**WELWYN HATFIELD BOROUGH COUNCIL
EXECUTIVE DIRECTOR - PLANNING, PUBLIC PROTECTION AND GOVERNANCE**

Application No: 6/2022/2530/HOUSE
Location: The Lodge 2 Northaw Place Coopers Lane Northaw Potters Bar EN6 4NQ
Proposal: Erection of a part-single, part-two storey side extension and part subterranean extension
Officer: Ms Kirsty Shirley

Recommendation: Refused

Title:
**First Floor & Roof Plans
as Proposed**

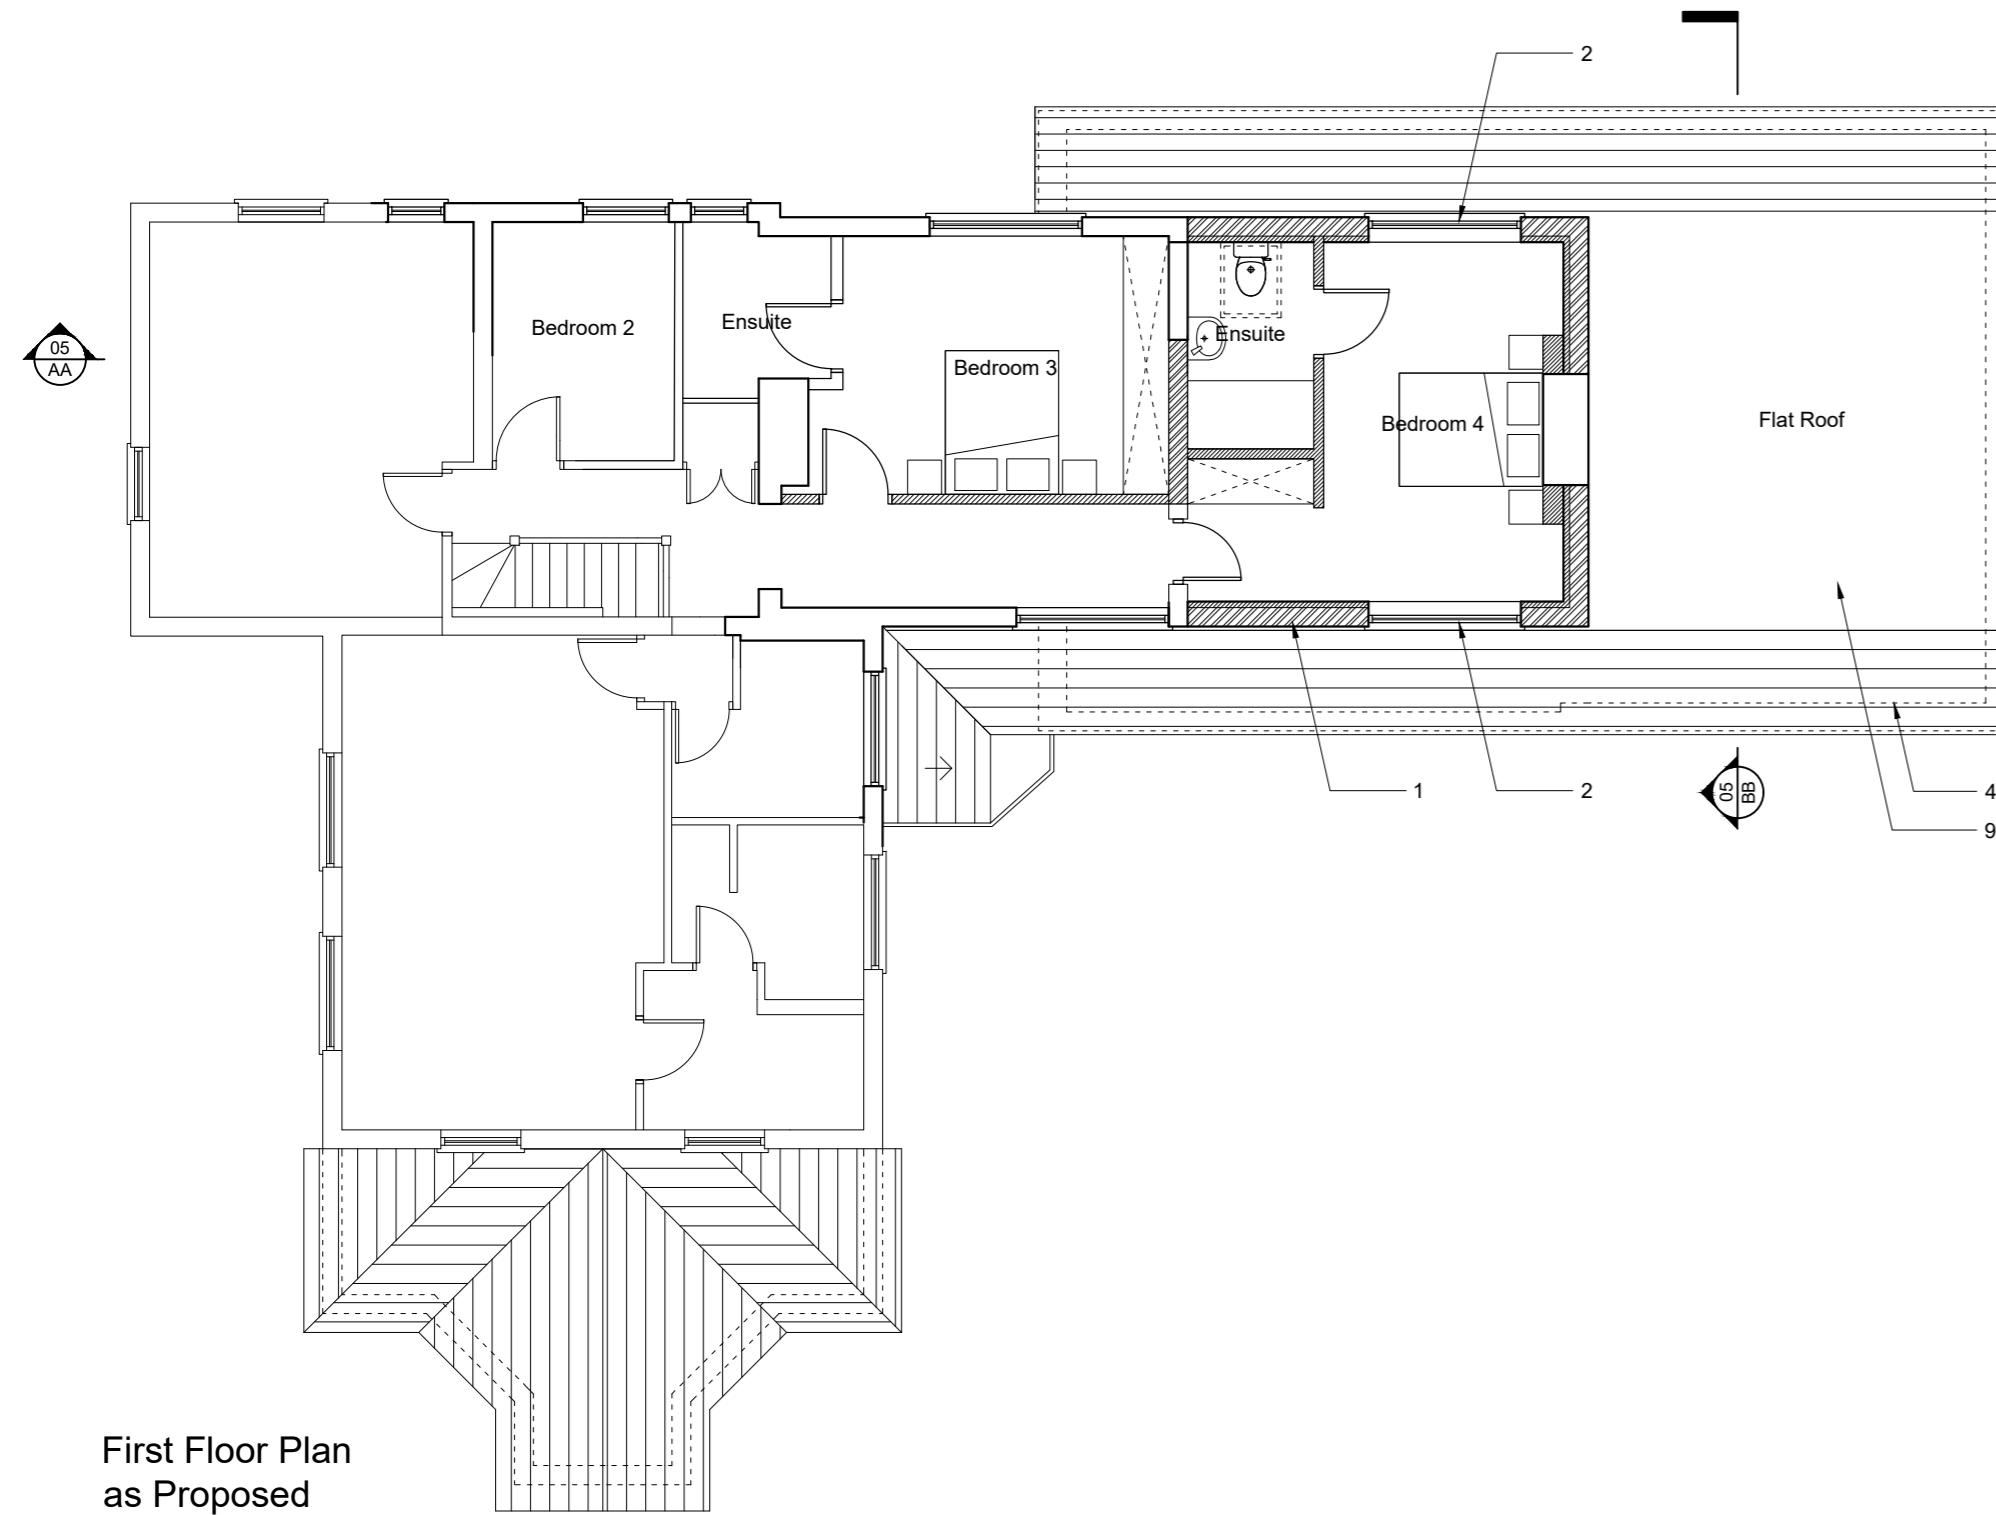
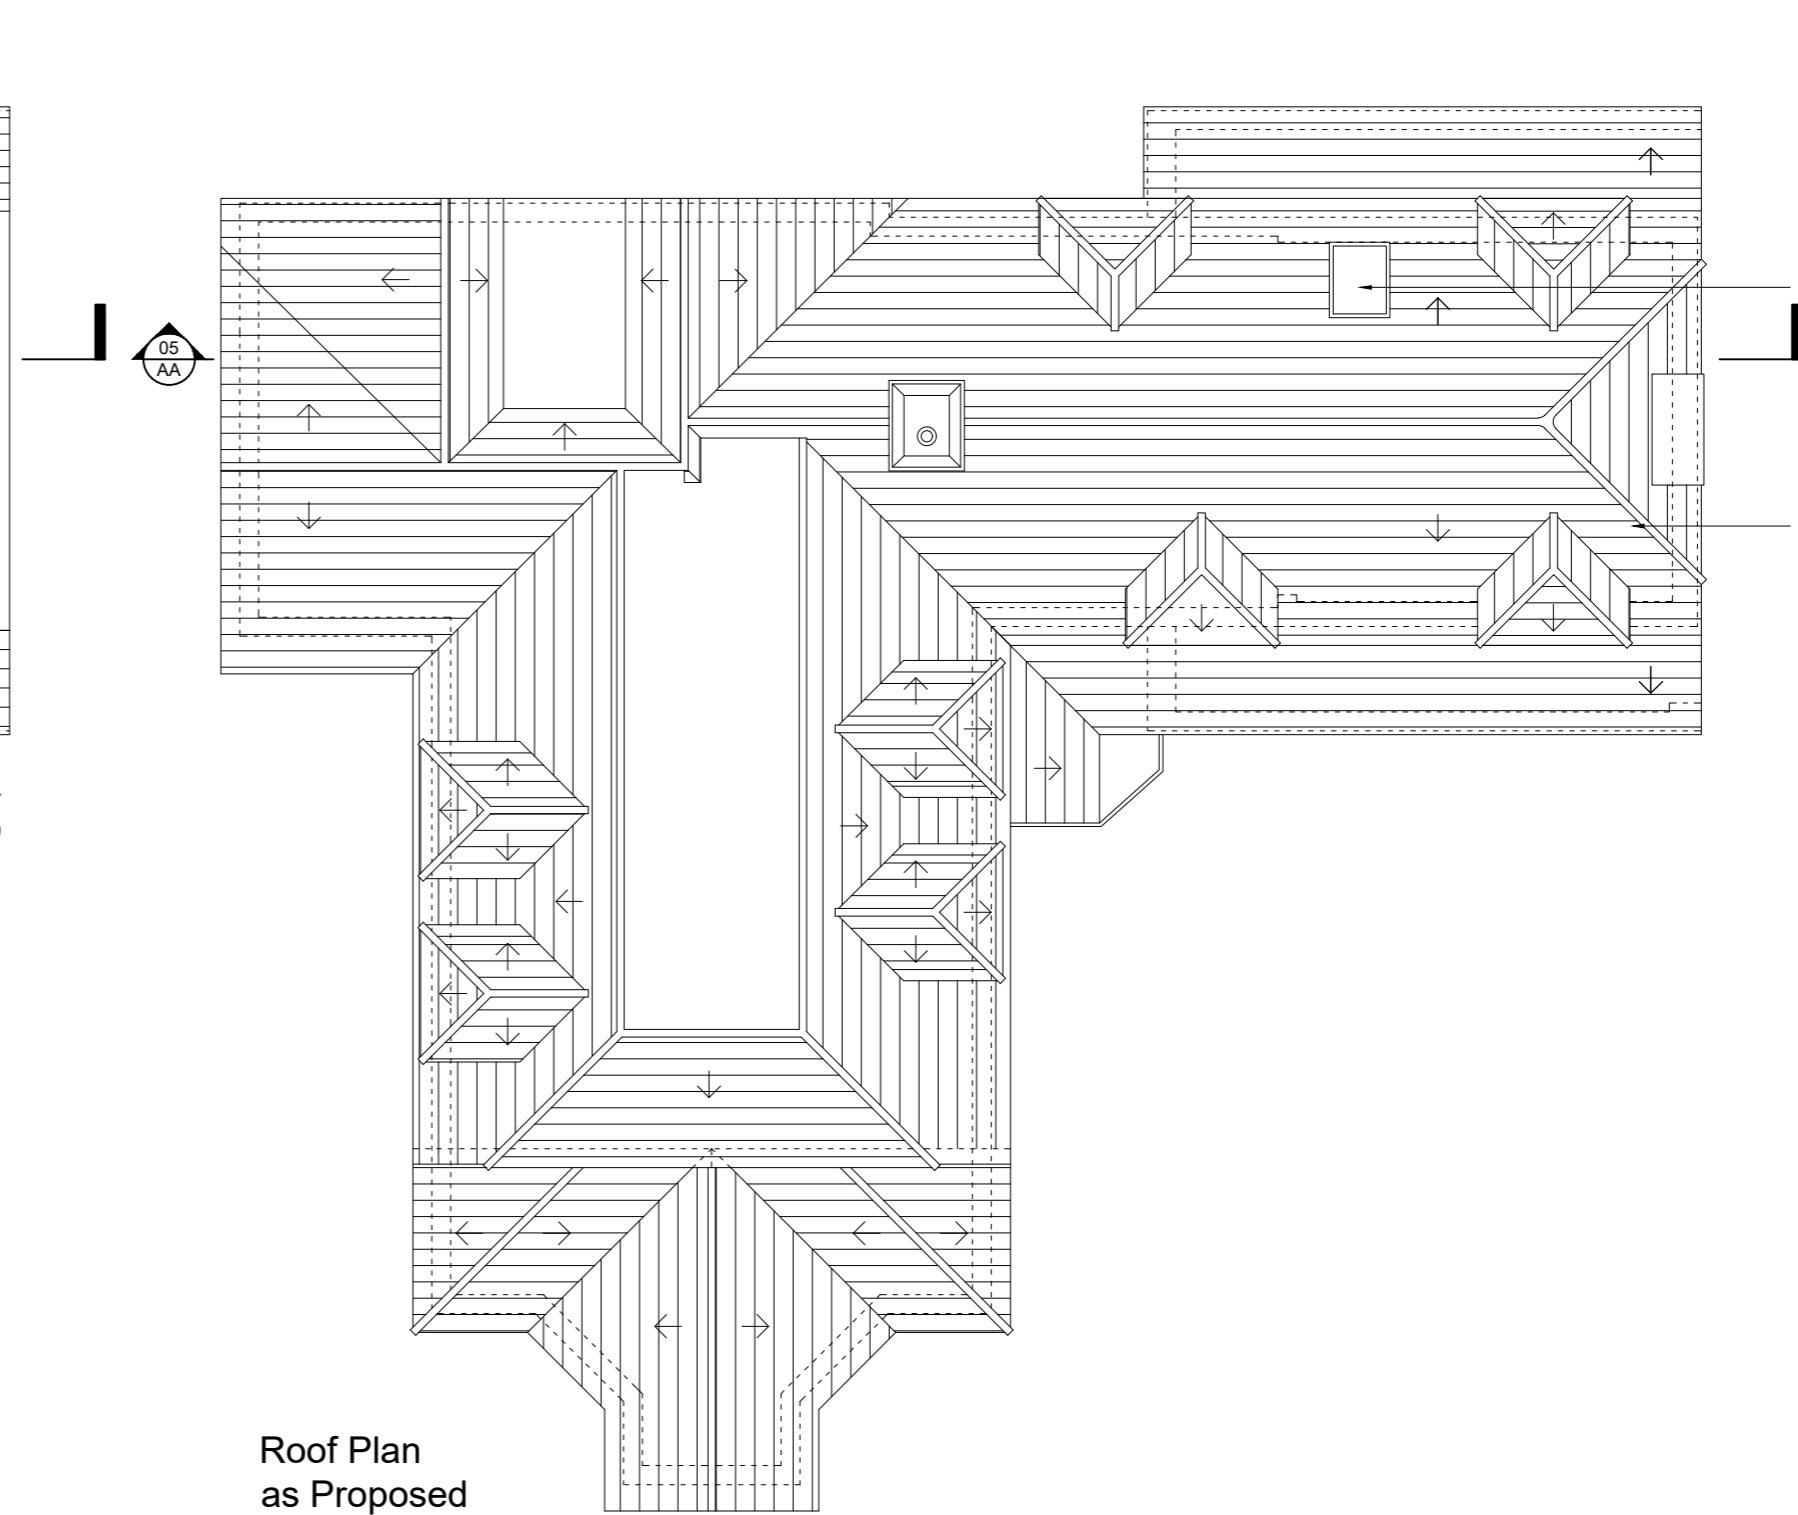
<p>this percentage further. The proposed development would result in an increase in footprint at ground and first floor level, as well as an increase in floor area at subterranean, ground and first floor level. The dwelling as existing already represents a disproportionate increase compared to the original dwelling and as such the proposed development would exacerbate the existing disproportion.</p> <p>In terms of a qualitative assessment, the first-floor extension has been reduced in size compared to previously refused application 6/2022/1508/HOUSE. However, the first-floor extension proposed in this current application still adds bulk and massing to the application dwelling. This application also includes subterranean development, which would add further bulk and massing to the dwelling.</p> <p>It is therefore considered that the proposed extension would be substantial in comparison to the original building as to be disproportionate. The proposal therefore represents inappropriate development within the Green Belt. The NPPF confirms that inappropriate development is by definition harmful to the Green Belt.</p> <p><i>Openness</i></p> <p>The NPPF identifies the essential characteristics of Green Belts are their openness and their permanence. There is no definition of openness in the NPPF but, in the context of the Green Belt, it is generally held to refer to freedom from, or the absence of, development. However, assessing the impact of a proposal on the openness of the Green Belt requires a judgment based on the circumstances of the case.</p> <p>Openness is capable of having both spatial and visual aspects - in other words, the visual impact of the proposal may be relevant. The specific characteristics of the proposal and its setting are also relevant in this case when making an assessment.</p> <p>The application dwelling is setback from the Coopers Lane and is mostly screened by fencing and vegetation. The subterranean development would be mostly concealed from view due to its positioning below the application dwelling. However, a lightwell and a balustrade surrounding the lightwell would indicate the presence of subterranean development. The intensification of such paraphernalia would diminish the openness of the site.</p> <p>Furthermore, while the first-floor development has been reduced in size compared to previously refused application 6/2022/1508/HOUSE, the development would still introduce built form in an area which currently provides open space.</p> <p>Consequently, the development would result in a material loss of Green Belt openness in spatial terms and the proposal therefore fails to overcome refusal reason 1 of 6/2022/1508/HOUSE.</p>

Title:  
**Elevations and Sections  
as Proposed**

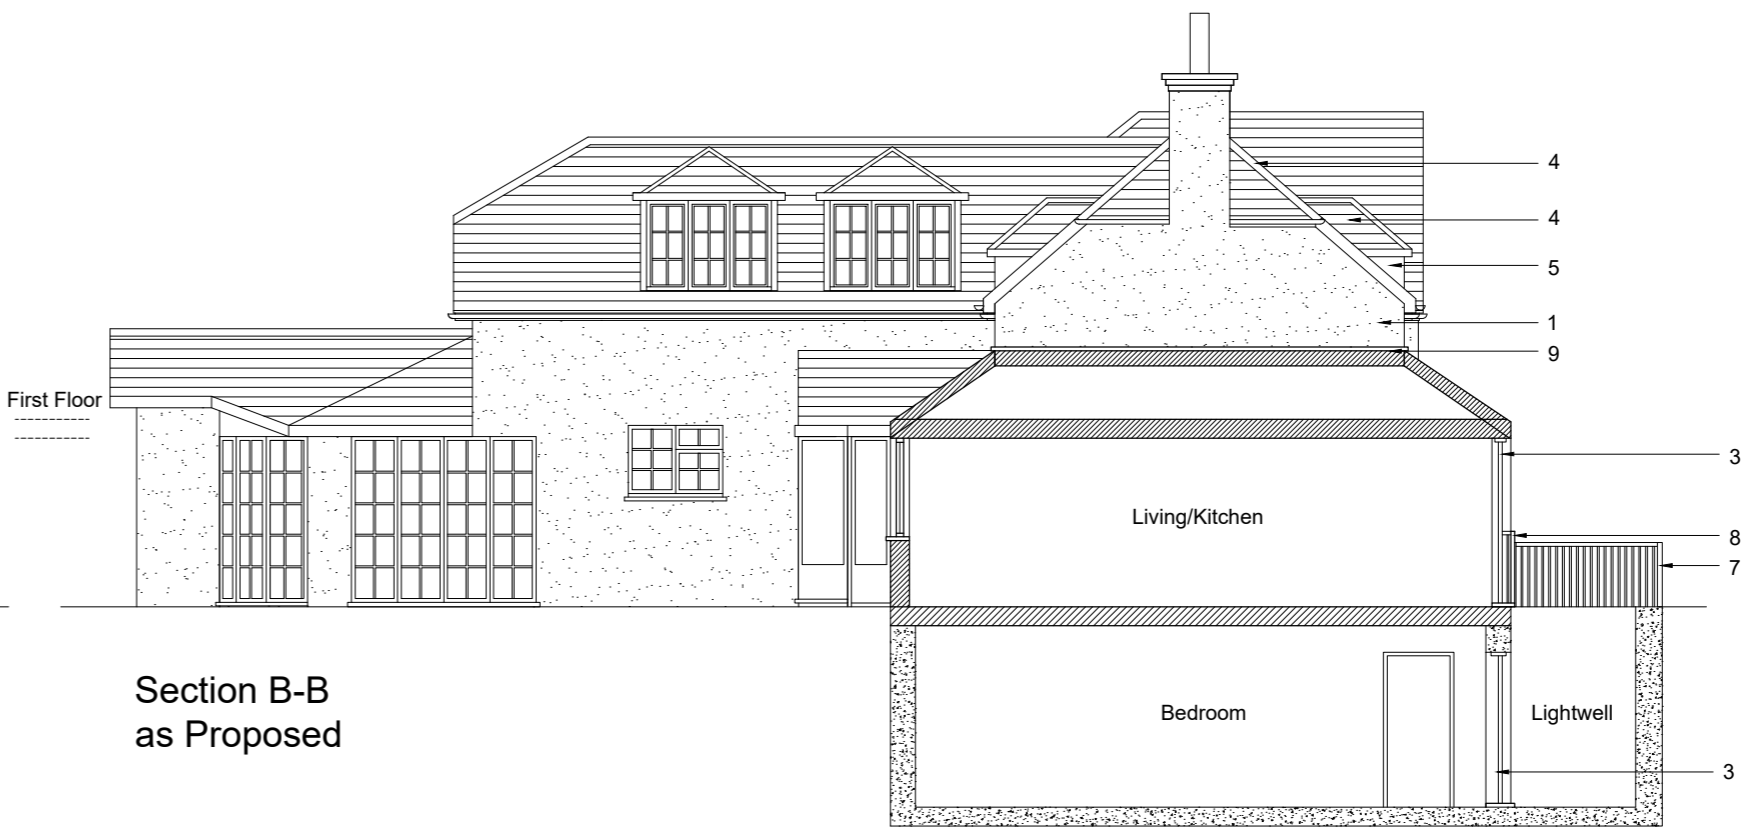
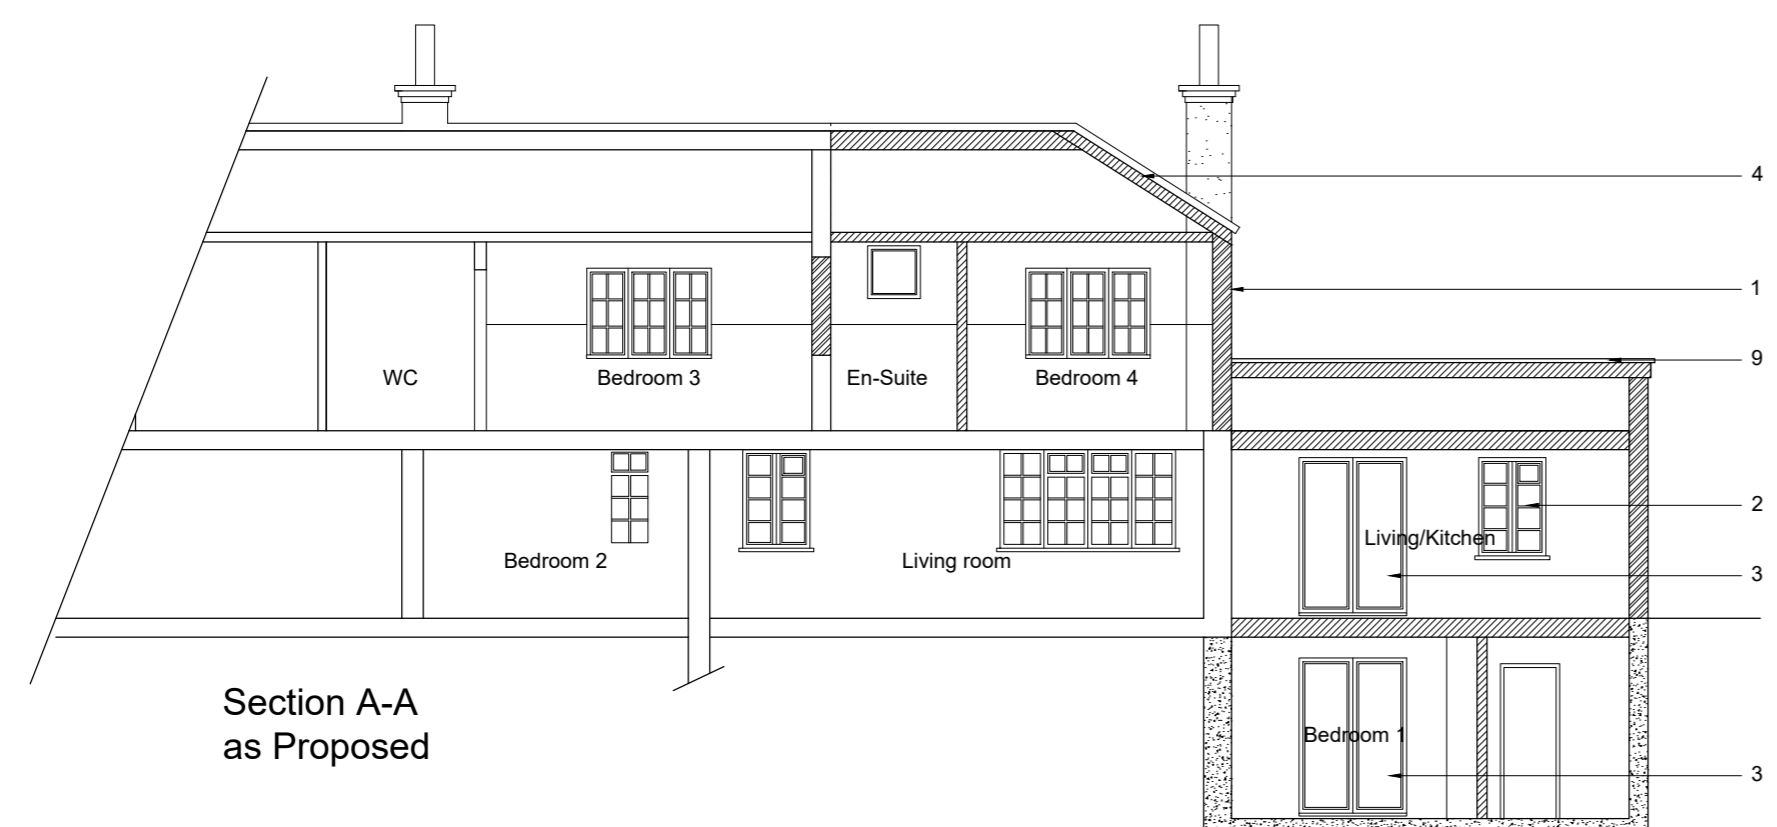
<p>streetscene)</p>	<p>which it is proposed, maintaining and where possible enhancing the character of the existing area. These policies are expanded upon in the Council's Supplementary Design Guidance (SDG) which requires the impact of a development to be assessed giving regard to the bulk, scale and design of the proposal and how it harmonises with the existing building and area.</p> <p>The proposed ground floor extension would be very limited in scale and would appear subservient to the existing dwelling.</p> <p>The first-floor extension would also appear as a subservient addition to the application dwelling and would feature a half-hipped roof which would be in keeping with the half-hipped roofs featured elsewhere on the dwelling.</p> <p>Four dormers would be inserted into the roof slope, with two on the front facing roofslope and two on the rear facing roofslope. The proposed dormers would appear similar in style, design and scale to the existing dormers on the south facing roofslope. As well, the dormers would be set below the ridge height, appear subservient within the roofslope and having matching fenestration to the windows of the dwelling.</p> <p>The subterranean development would be concealed underground with a modest lightwell serving the underground space to the rear of the dwelling that would be mostly obscured from view due to the surrounding balustrade. The scale and positioning of the balustrade would not appear out of keeping within a domestic garden setting and would not detract from the character of the area.</p> <p>It is therefore considered that the proposed development has overcome previous refusal reason 2 of application 6/2022/1508/HOUSE.</p>
